Application for a non-material amendment following a grant of planning permission.

Adding Patio Doors to the Ground Floor on the South Elevation

Drawing Numbers Dwg. 2021063/PL1B and 2A

Drawing Numbers Dwg. 2021063/PL1C and 2B

Proposed South Elevation

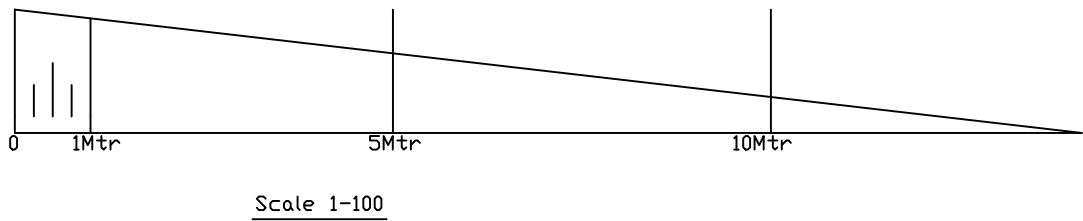
To let more light into the Kitchen/ Dining Area
